PROJECT NO. PR-2022-007875
Application No. SI-2022-02109-SITE PLAN

SUBMITTAL DESCRIPTION: Revised Site Plan, Landscape Plan Infrastructure List and Deviation Justification

Memorandum

Project: Kimmick & Rosa Parks

1 PERIMETER WALL ELEVATION  
Scale: 1"=5"

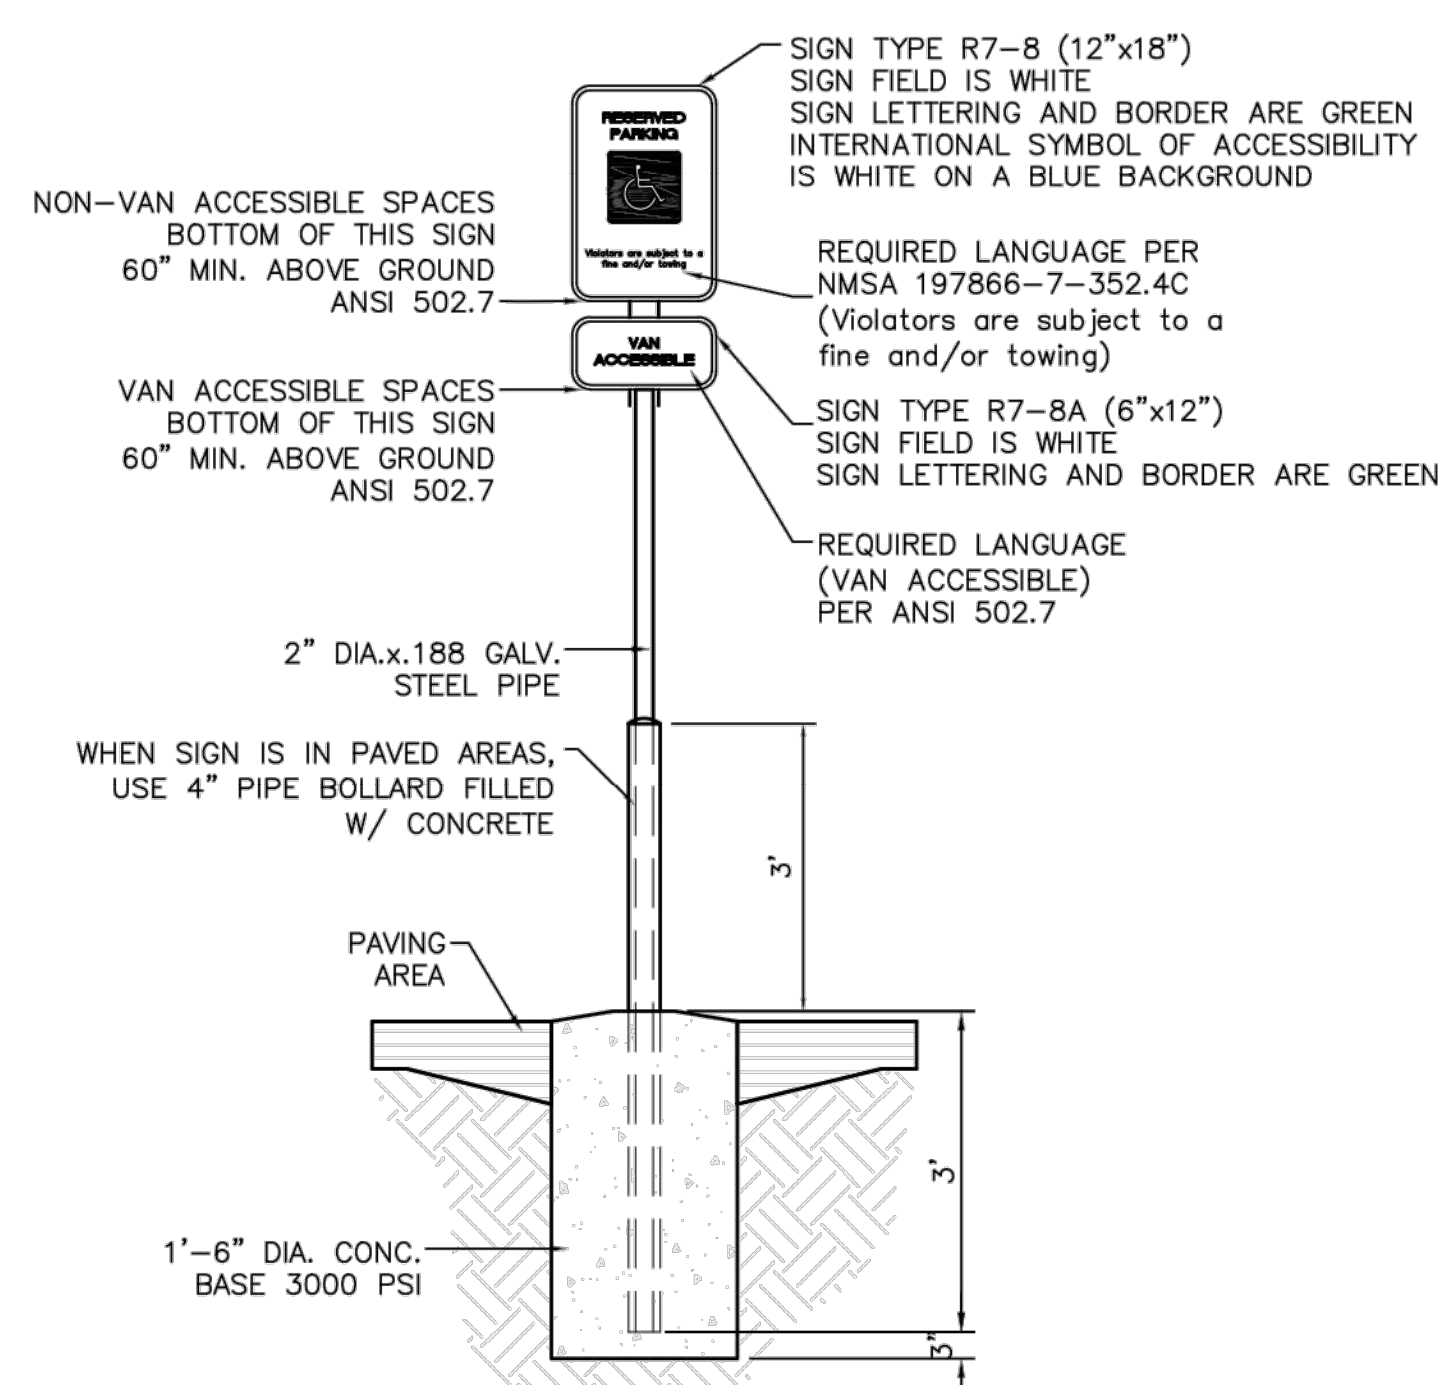
Locate and design all walls, fences, retaining walls, and combinations of those site features facing the Major Public Open Space in compliance with all applicable standards in Section 14-16-5-7(E)(4) (Walls Adjacent to Major Arroyos or Major Public Open Space).

Design consideration has been made to ensure compliance to the standards outlined in Section 14-16-5-7(E). Garden walls will be constructed of CMU block and coated with stucco. No wall will be higher than the 6' maximum height restriction. Community walls facing public roadways and Major Public Open Space will be constructed of CMU block with an overhang top cap.

8 MONUMENT SIGN DETAIL  
Scale: NTS

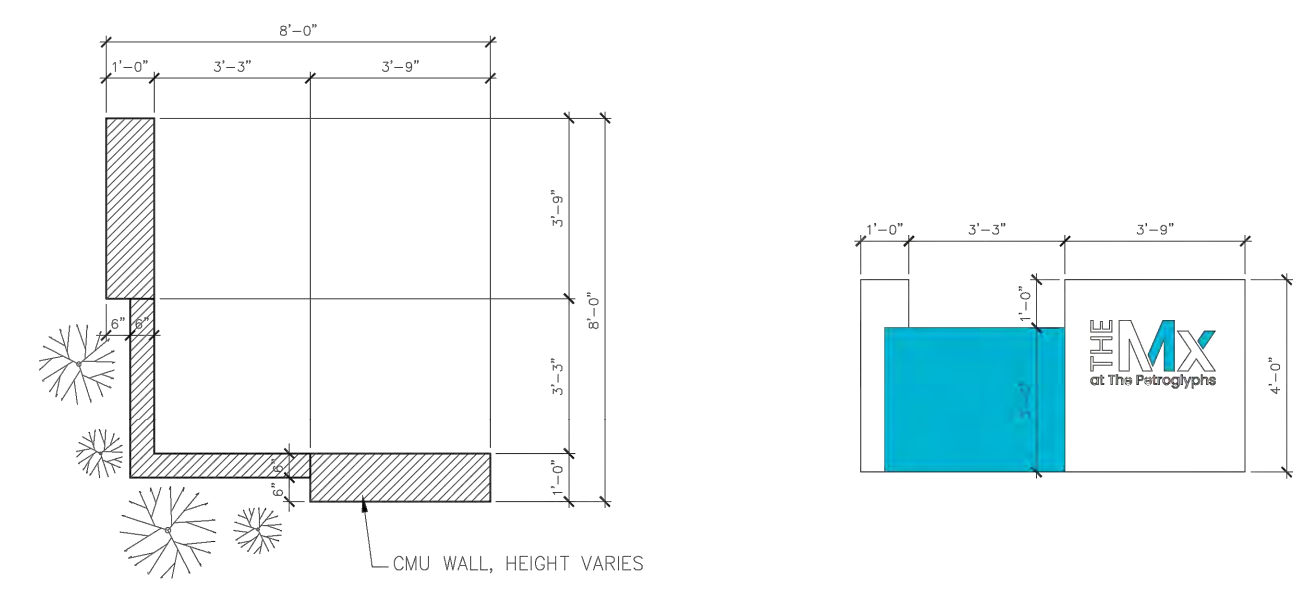
1. *Electronic signs are prohibited pursuant to Subsection 14-16-5-12(H)(2)(e).*
2. *Signage shall be located to minimize visibility from Major Public Open Space and designed pursuant to Subsection 14-16-5-12(E)(5) (Illumination and Motion).*

No electronic signage is being proposed in relation to this project. Design consideration has been made to minimize visibility from MPOS. The only signage being proposed is monumentation at the northwest and southwest corners of the property. Specific location and sizing of signage monumentation is shown on the landscaping plan.

**C2**

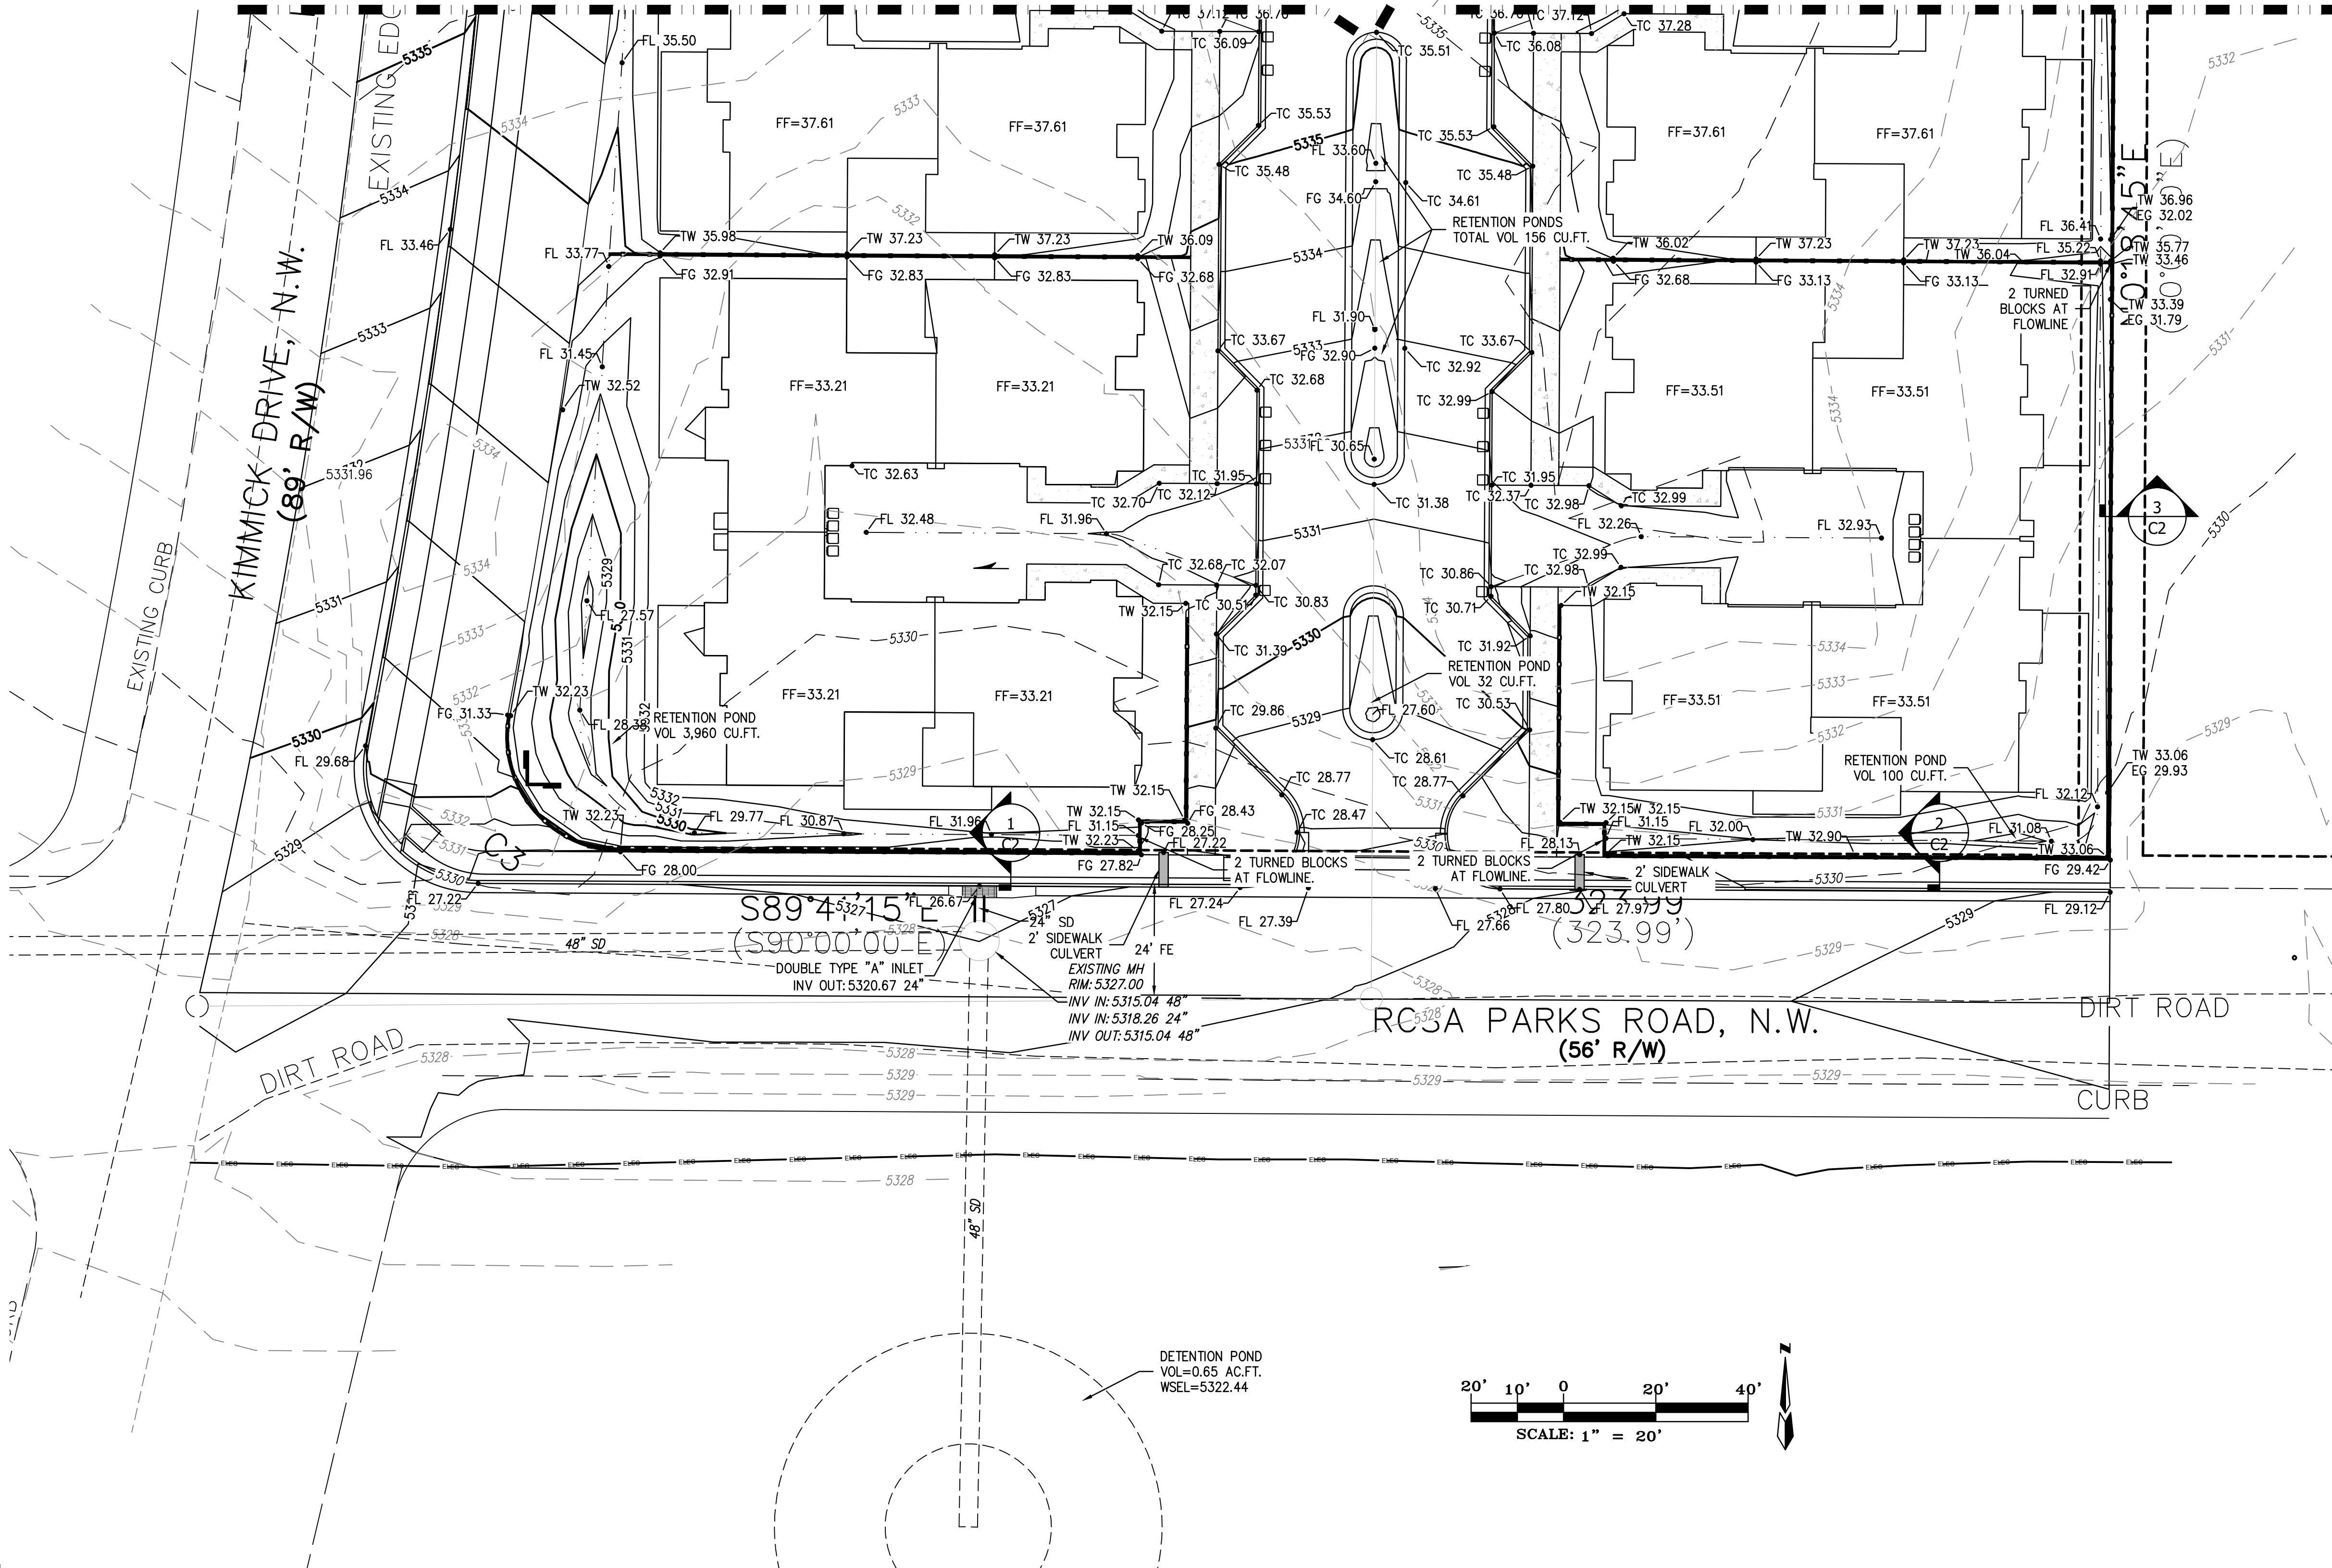
Design grading per Subsection 14-16-5-4(J)

All grading and erosion control practices will comply with the DPM. Design consideration has been made to ensure that new development blends into the adjacent environment with minimum grade change. See Sheet C2 grading plan for finished grade elevations.
